# CITY OF ALBUQUERQUE

**Re: Slim Chicken - Albuquerque**  
**8240 Montgomery Blvd NE**  
**Traffic Circulation Layout**  
Engineer's Stamp 05-18-2022 (G19-D004E)

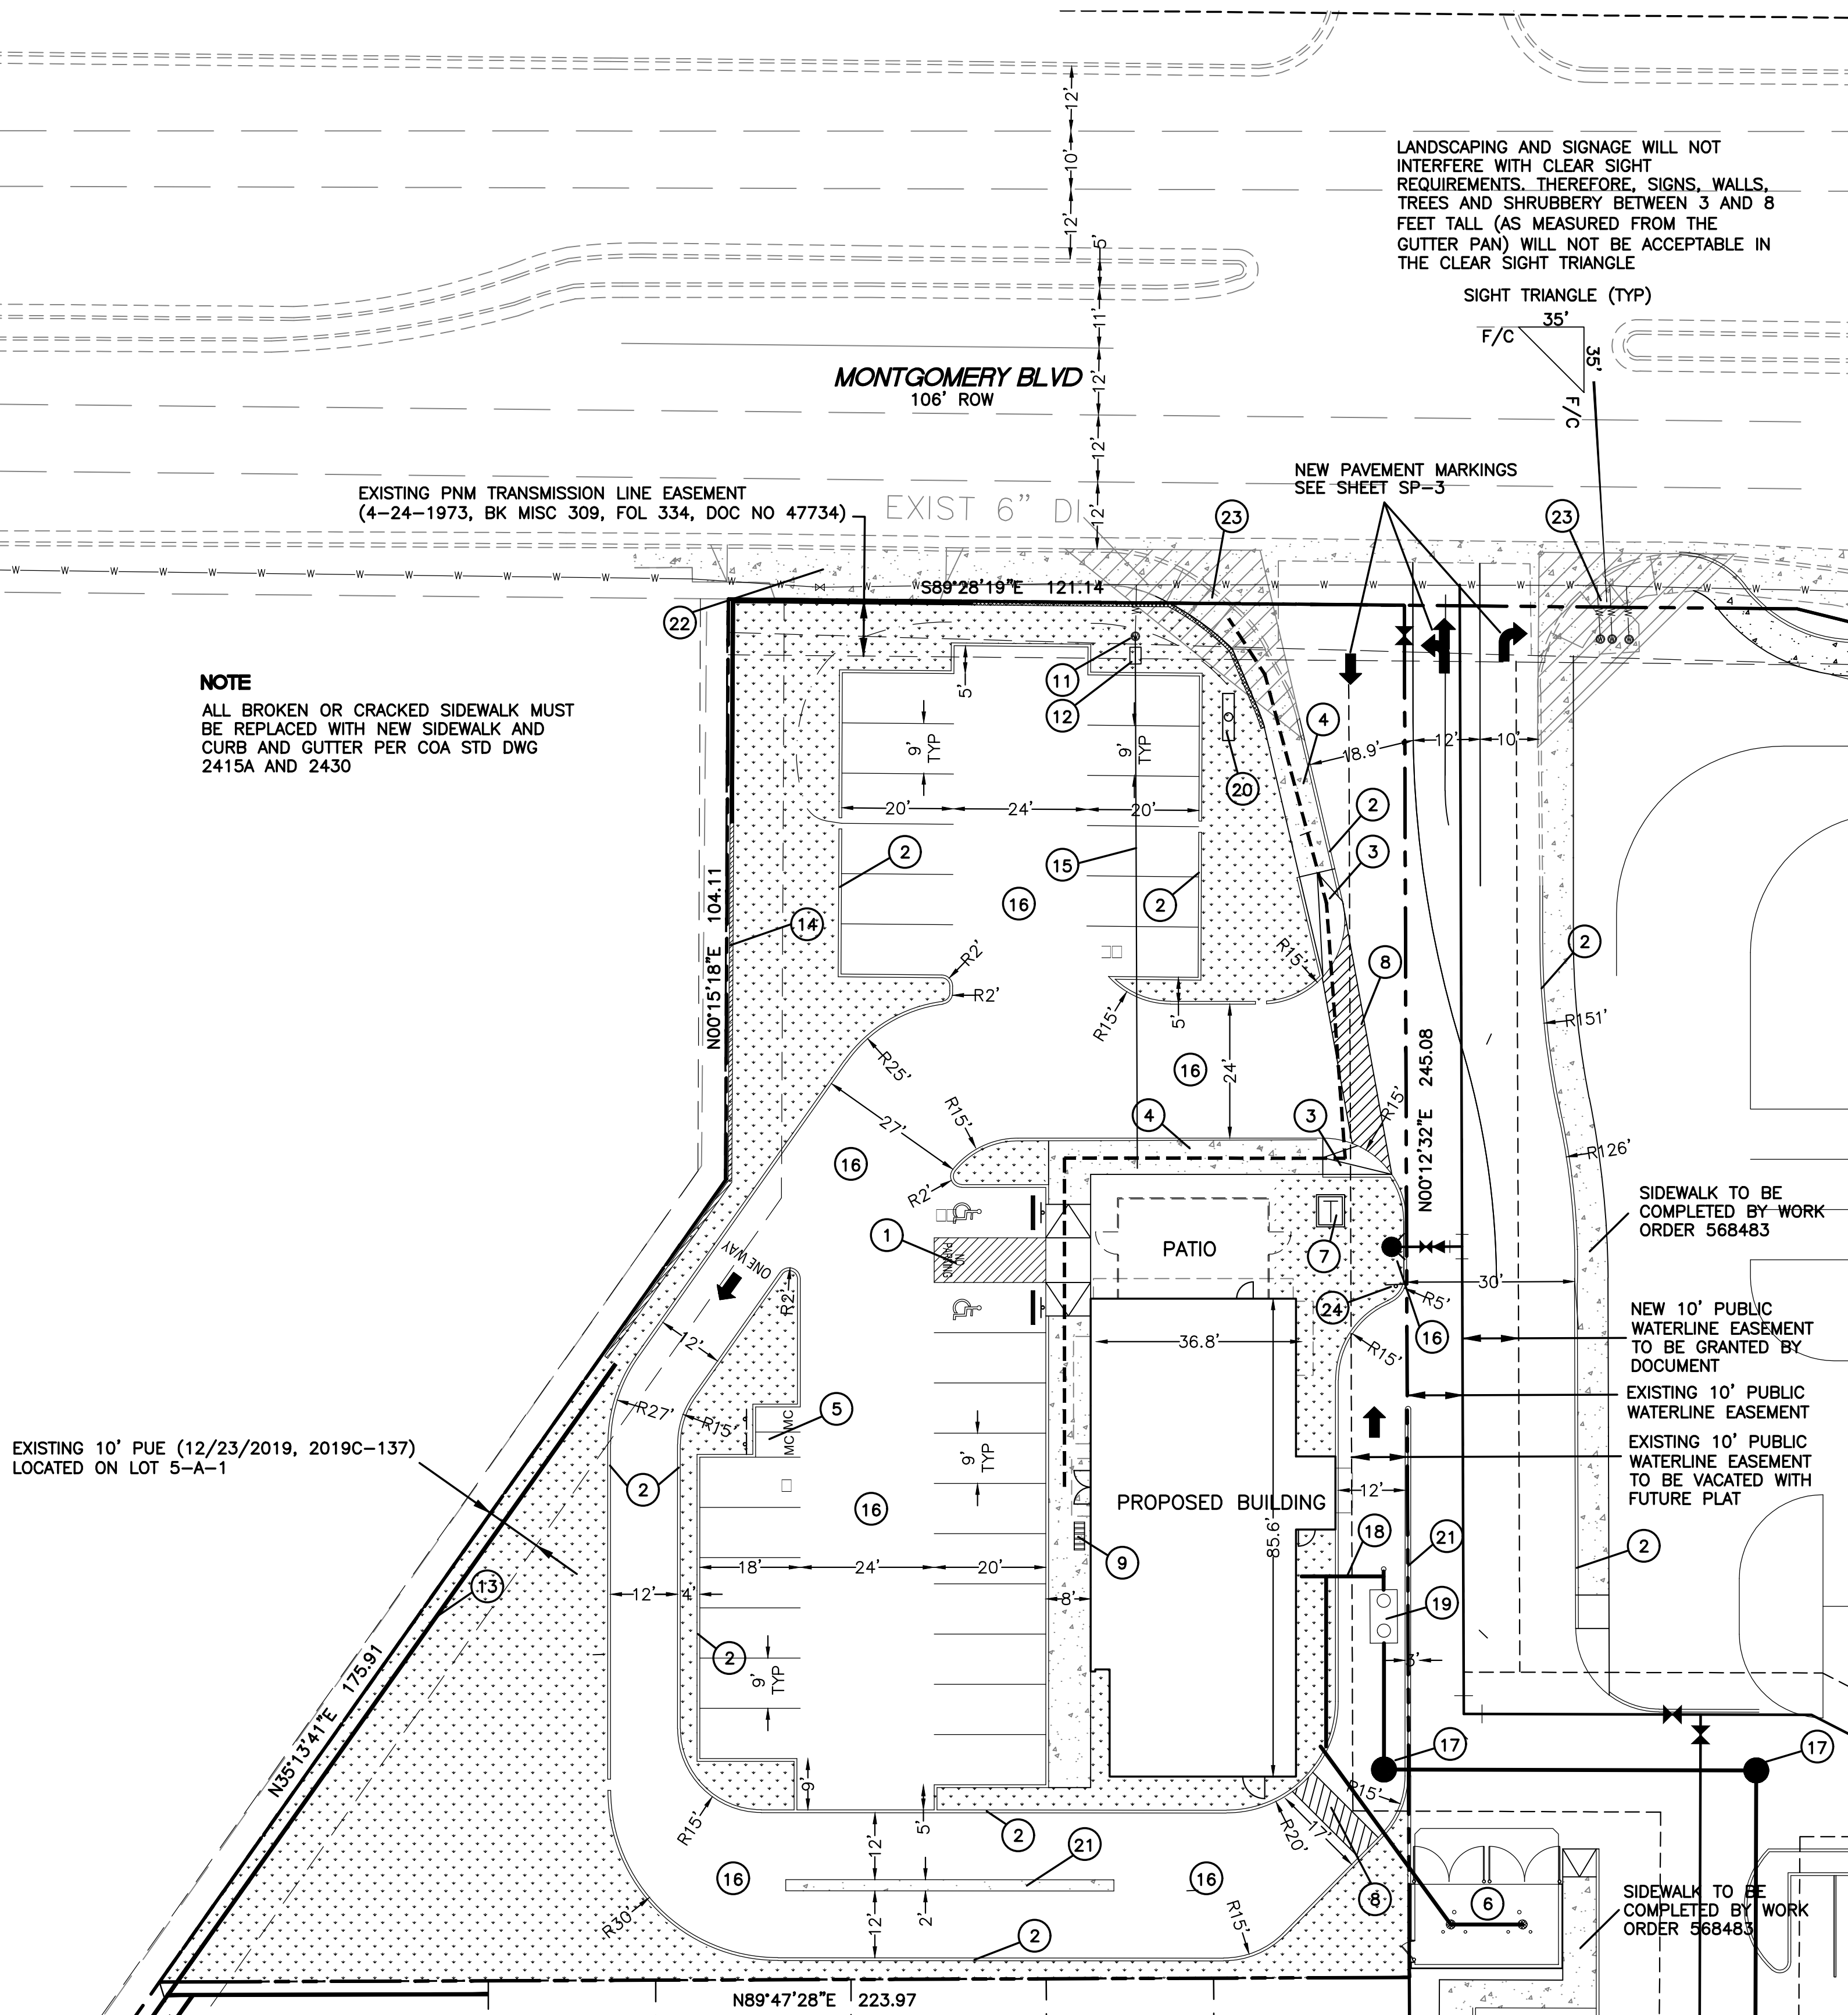
- Suggestion: redesign the main entrance per COA std dwg. 2426 to provide a 6' valley gutter with 1" invert. Replace the existing 4' valley gutter with 6' valley gutter to serve ADA across the entrance.

- The proposed drive aisle located mostly on tract 2. Please provide certified agreement with Tract 2 land owner.
- Plat for Wymont subdivision keynote 40: Private Rodway Easement should serve Tract 1-8. And on sheet 6 the location of driveway easement doesn't match the proposed drive aisle. The easement will need to encompass the proposed drive aisle shown on site plan. Please address this concern.
- Plat for Wymont subdivision keynote 41: Public sidewalk easement doesn't match site plan.
- Provide sidewalk connectivity to serve Tract 2.
- The main drive aisle will need striping for ingress/egress vehicles movement. Striping will be needed on the frontage segment of Slim Chicken.

- Provide striping and arrows for the 24' proposed entrance.
- Drive-thru lane: The exit lane has not throat depth for sight distance (on coming trafficnight vision with oncoming headligths and opposing traffic perception reaction). Please provide one storage length at exit to straighten vehicle for reaction of oncoming vehicles in both directions.
- You will need the following: All one-way drives shall have "One Way" and "Do Not Enter" signage (both sides on exit) and pavement markings. Please show detail and location of posted signs and striping (include Stop Sign and sign face details).

- The exit vehicular movement will be dedicated to a left turn movement ONLY. Provide a sign specifying left turn and no right turn out due to the tight radius which cannot accommodate the turn movement

- 7. Proposed Dumpster: Provide a letter from adjacent property owner stating that it is ok to have Dumpster located outside the lot of proposed development.
